Rezoning Transportation Analysis

Petition Number: 2023-017

Revision Log:	Date	Description
	06-28-23	First Review (PDM)
	10-25-23	Second Review (JP)
	11-27-23	Third Review (JP)

Rezoning Plan

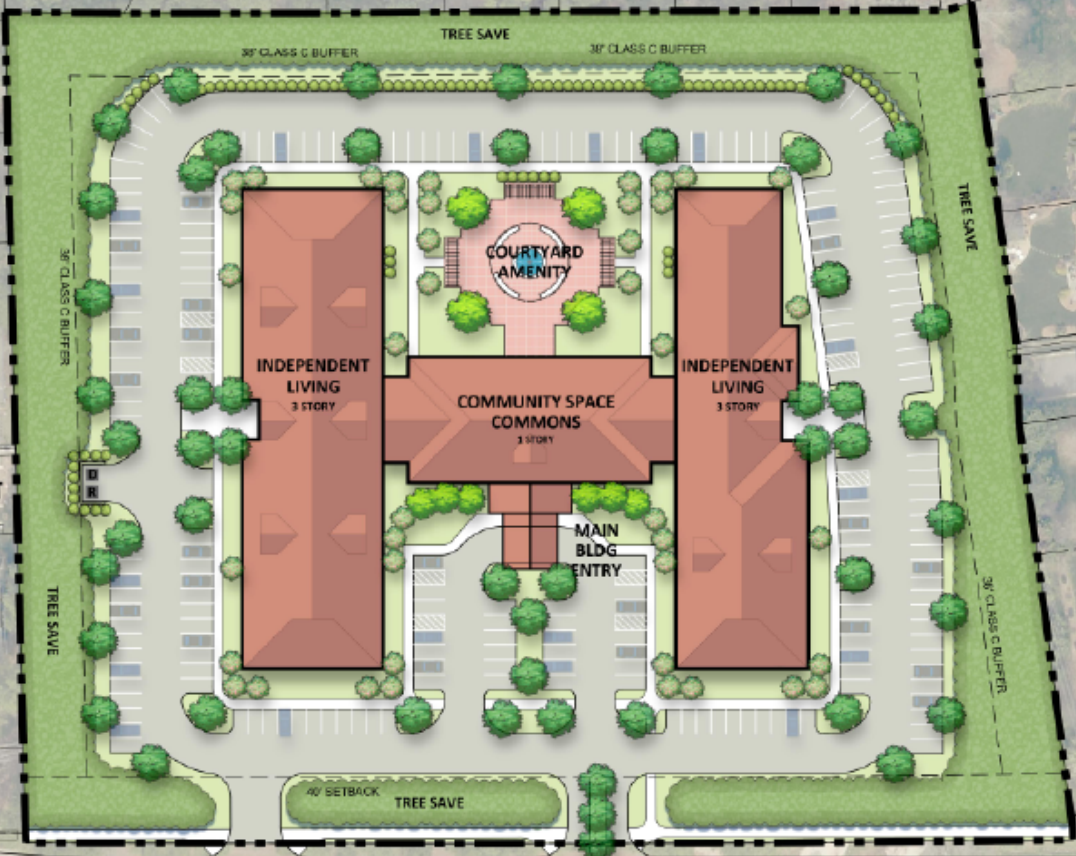
11. Add a conditional note specifying "the Petitioner shall dedicate and convey in fee simple all rights-of-way to the City before the site's first building certificate of occupancy is issued. CDOT requests rights-of-way set at 2' behind back of sidewalk where feasible."

12. Add a conditional note specifying "All transportation improvements will be approved and constructed before the site's first building certificate of occupancy is issued. The petitioner may phase transportation improvements if said improvements and phasing are explicitly described in site plan notes."

13. **New Comment 10.25.2023** — Revise proposed intersection improvements to construct matching short westbound left turn lane at location of full access driveway and newly constructed eastbound left turn lane.
